**KIRKLEES METROPOLITAN COUNCIL
INVESTMENT & REGENERATION SERVICE**

**DELEGATED DECISION FOR APPLICATION FOR CERTIFICATE OF
LAWFUL DEVELOPMENT**

Reference no.: 2022/CL/91542/W

Site: 8, Bent Lea, Bradley, Huddersfield, HD2 1QW

Dwg No. - 9597/02 RevA

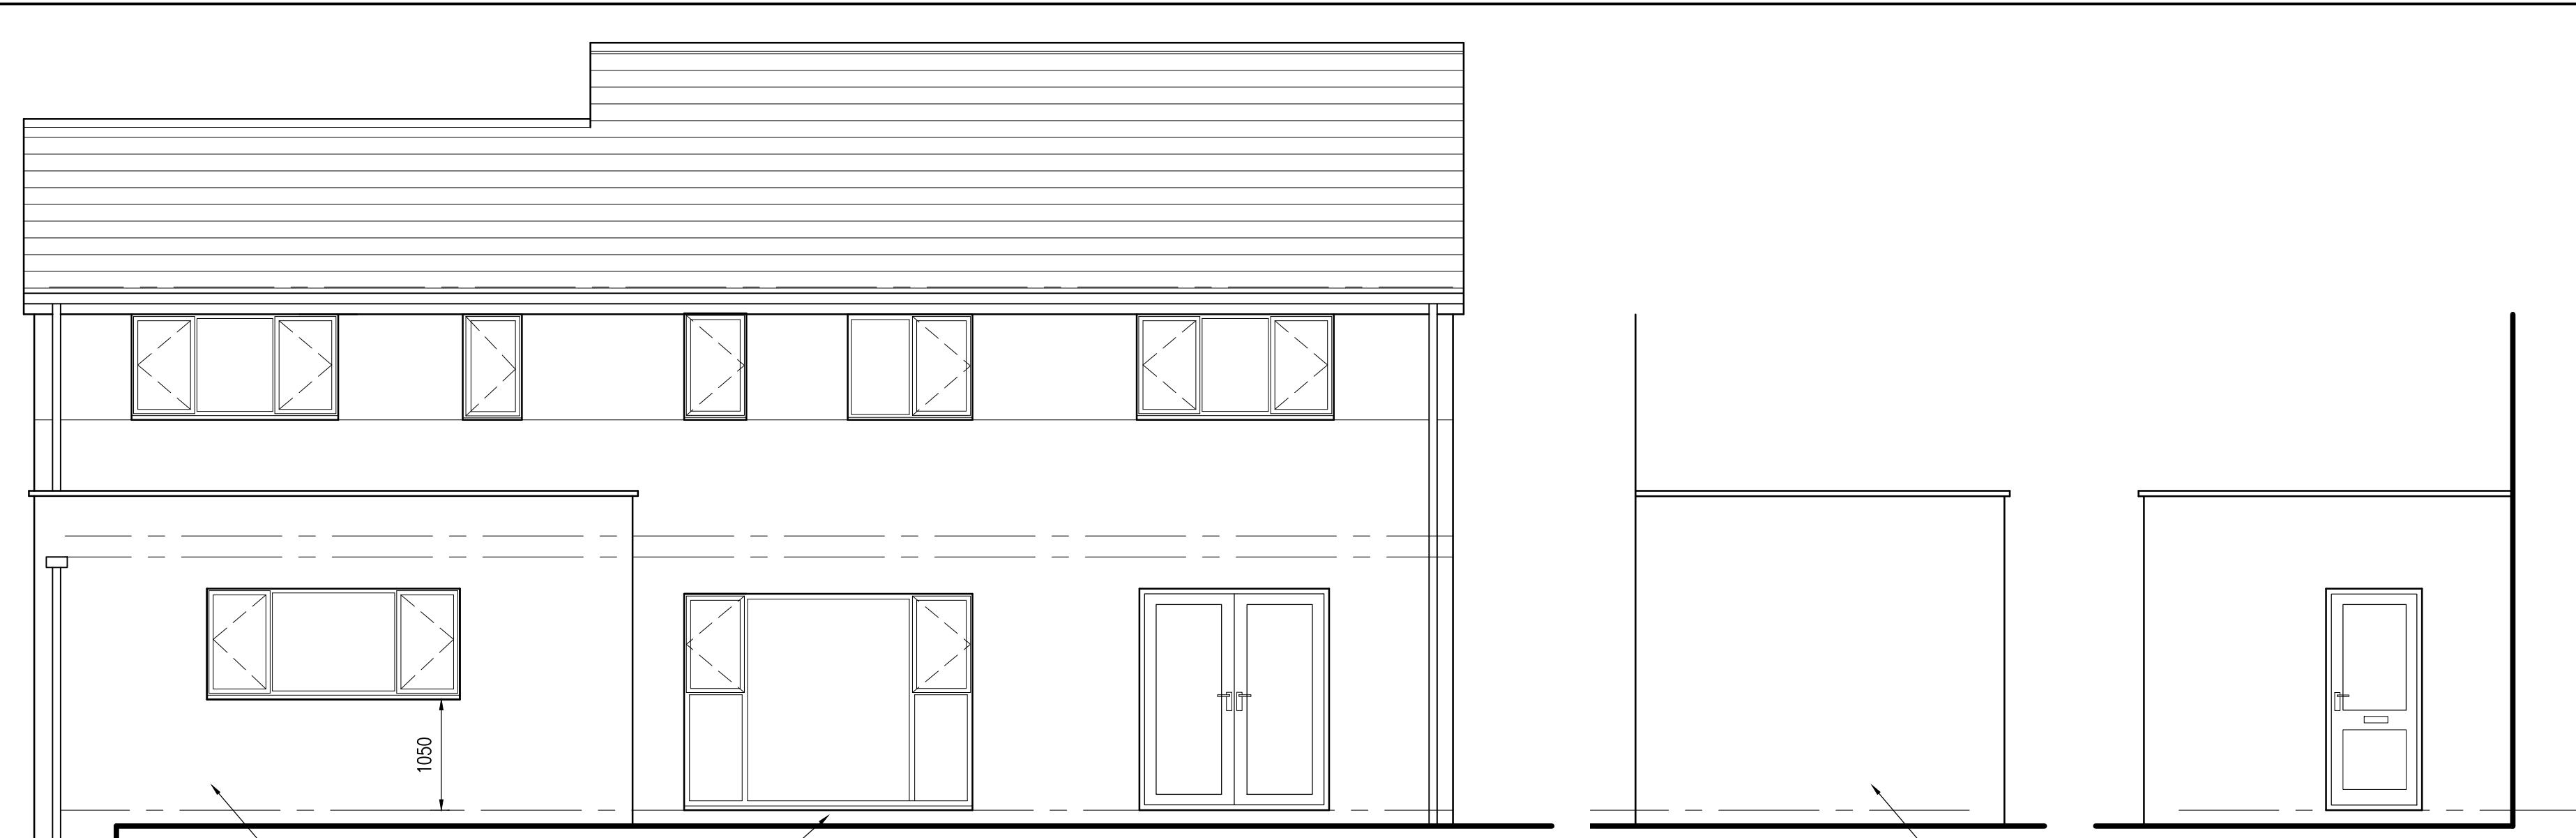
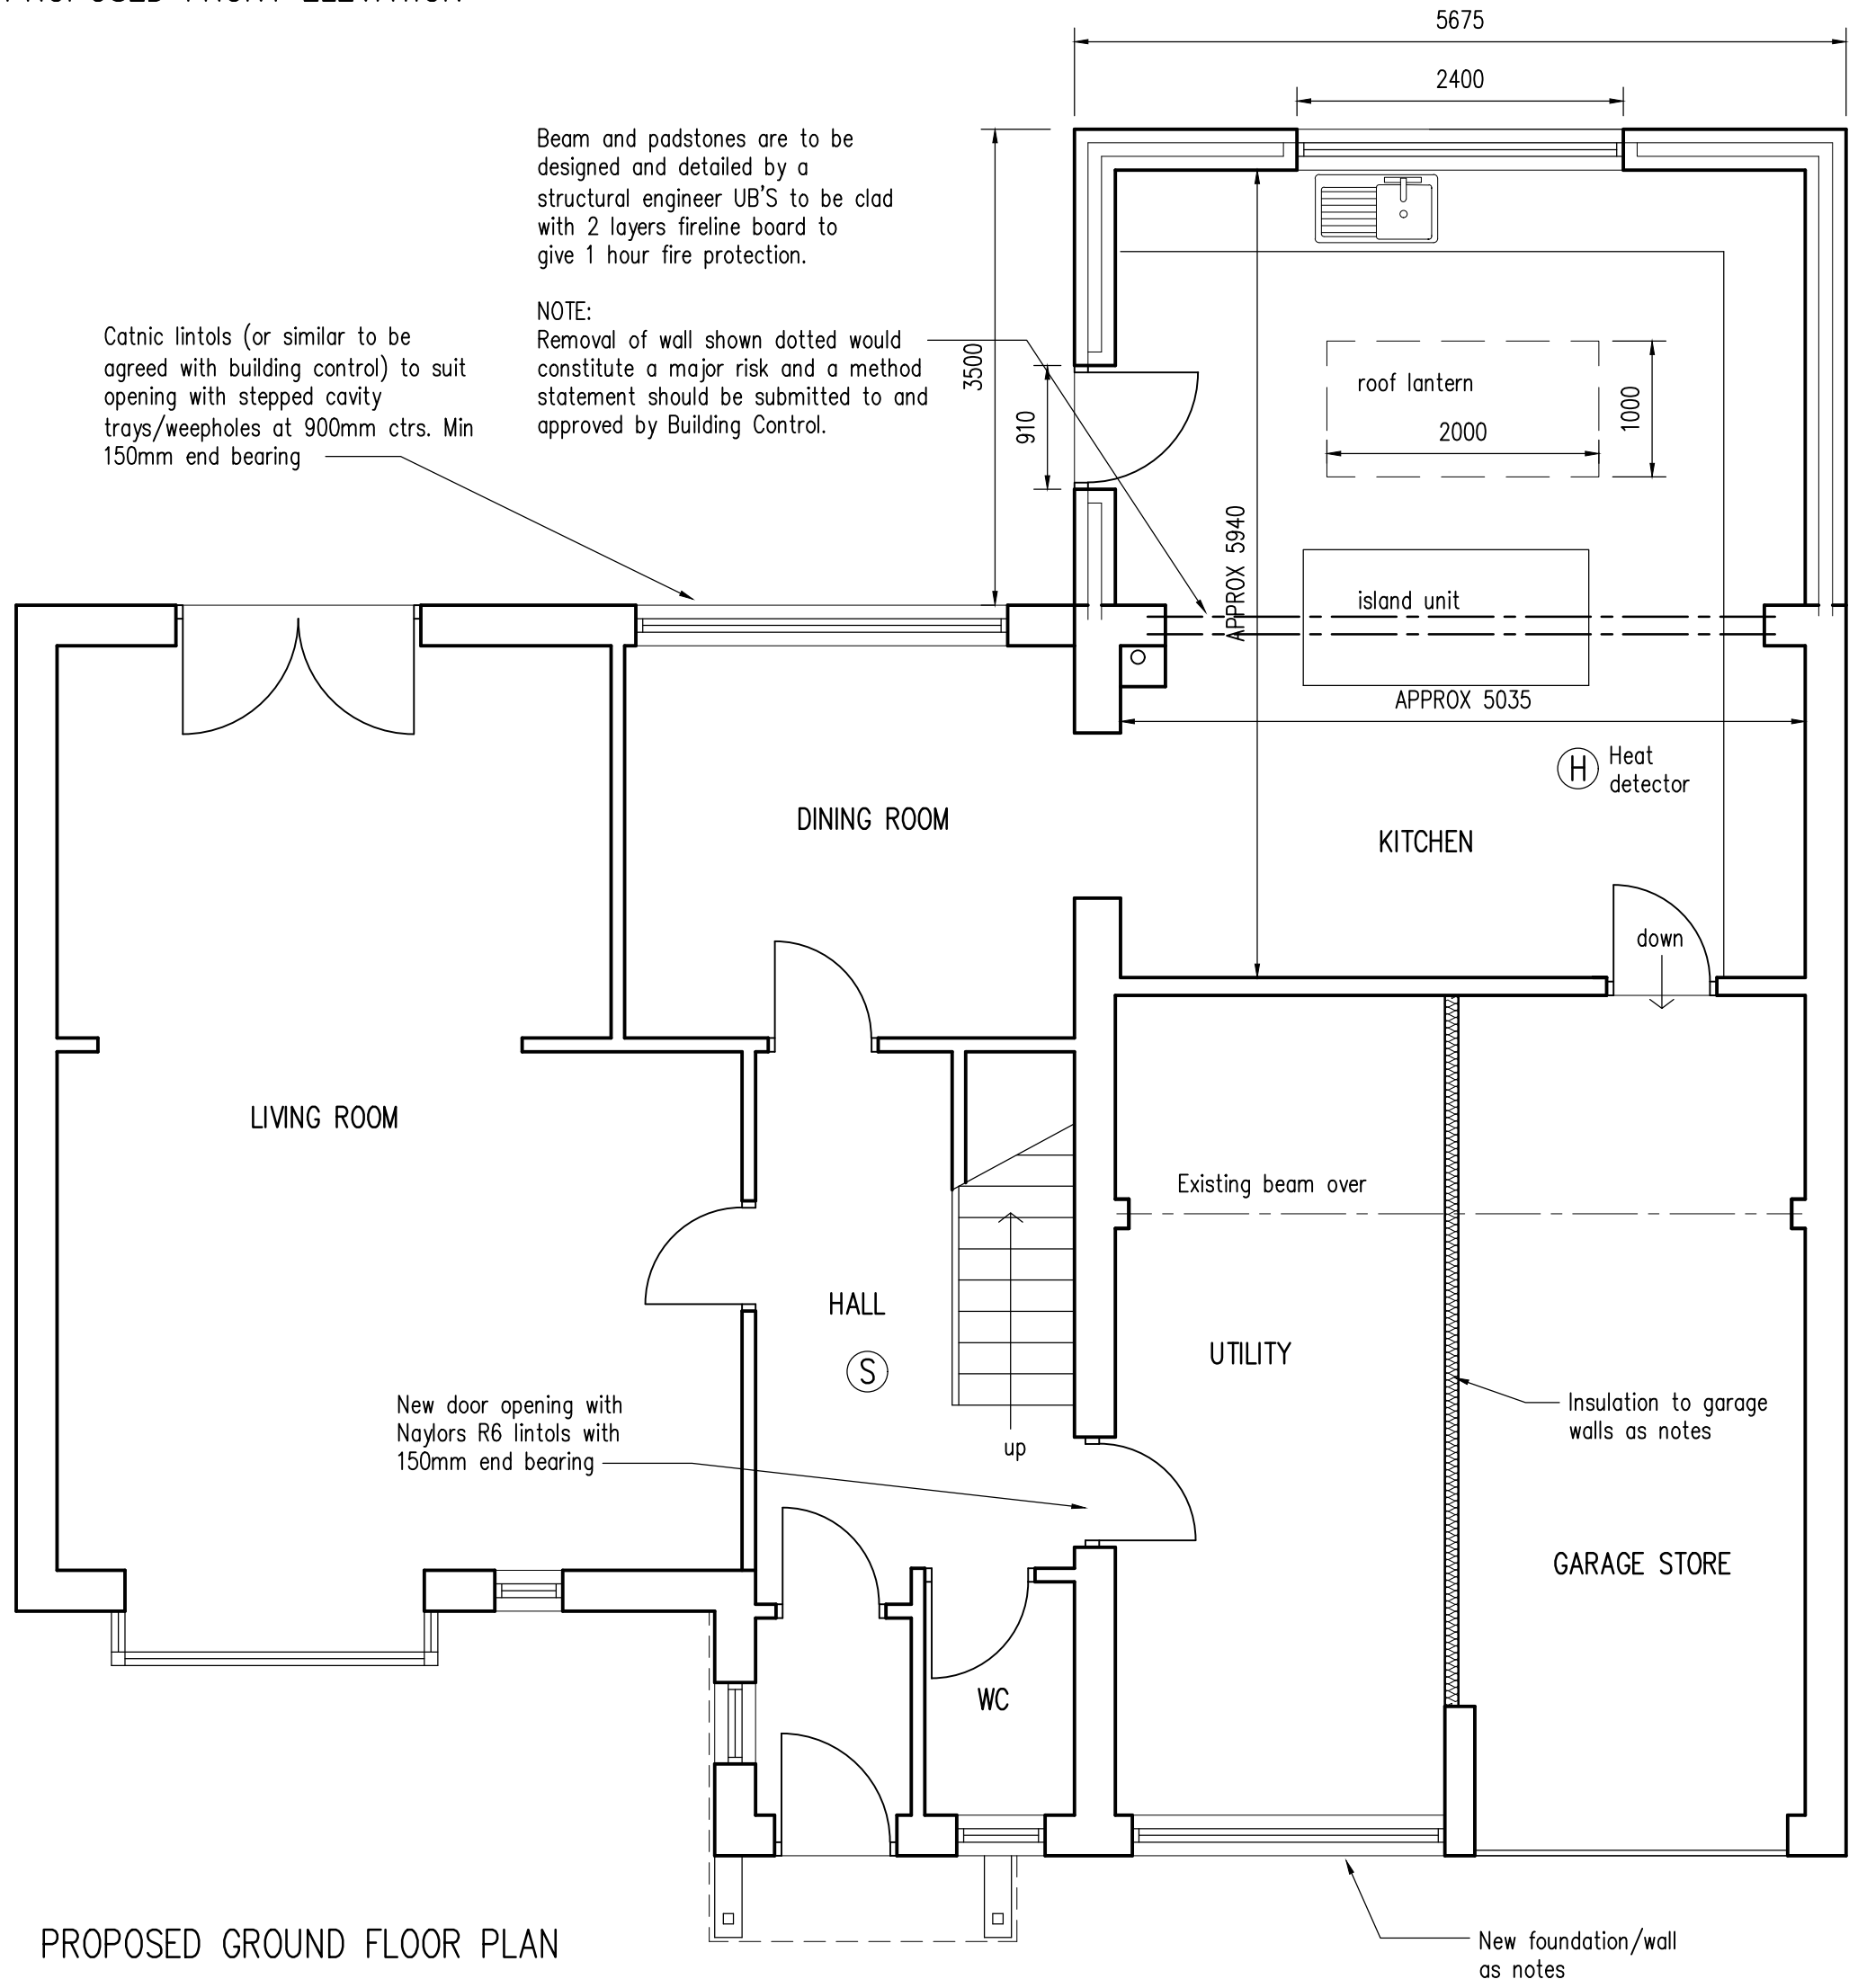
The proposed alterations to the property would be that within the front elevation of the property the garage door closest to the living accommodation would be removed and replaced with a window and within the rear elevation 3 no. windows would be removed and floor to ceiling window inserted.

The extension would project from the rear elevation of the property by 3.5 metres and would be a total width of 5.6 metres with the total height of the structure being 3.1 metres with a 600mm parapet wall surrounding the edge of the flat roof.

It is noted that the proposed front elevation roof lights have been removed as part of the revised submission.

Comment: The extension would not extend more than 4 metres from the rear of the existing dwellinghouse and would not exceed 4 metres in height

Comment: The enlargement would be within 2 metres of the boundary of the curtilage of the dwellinghouse however the eaves height would not exceed 3 metres

Comment: None of the above apply however a wastepipe is proposed.

Comment: The proposed materials would be to match the existing and no alterations to the upper floor windows are proposed
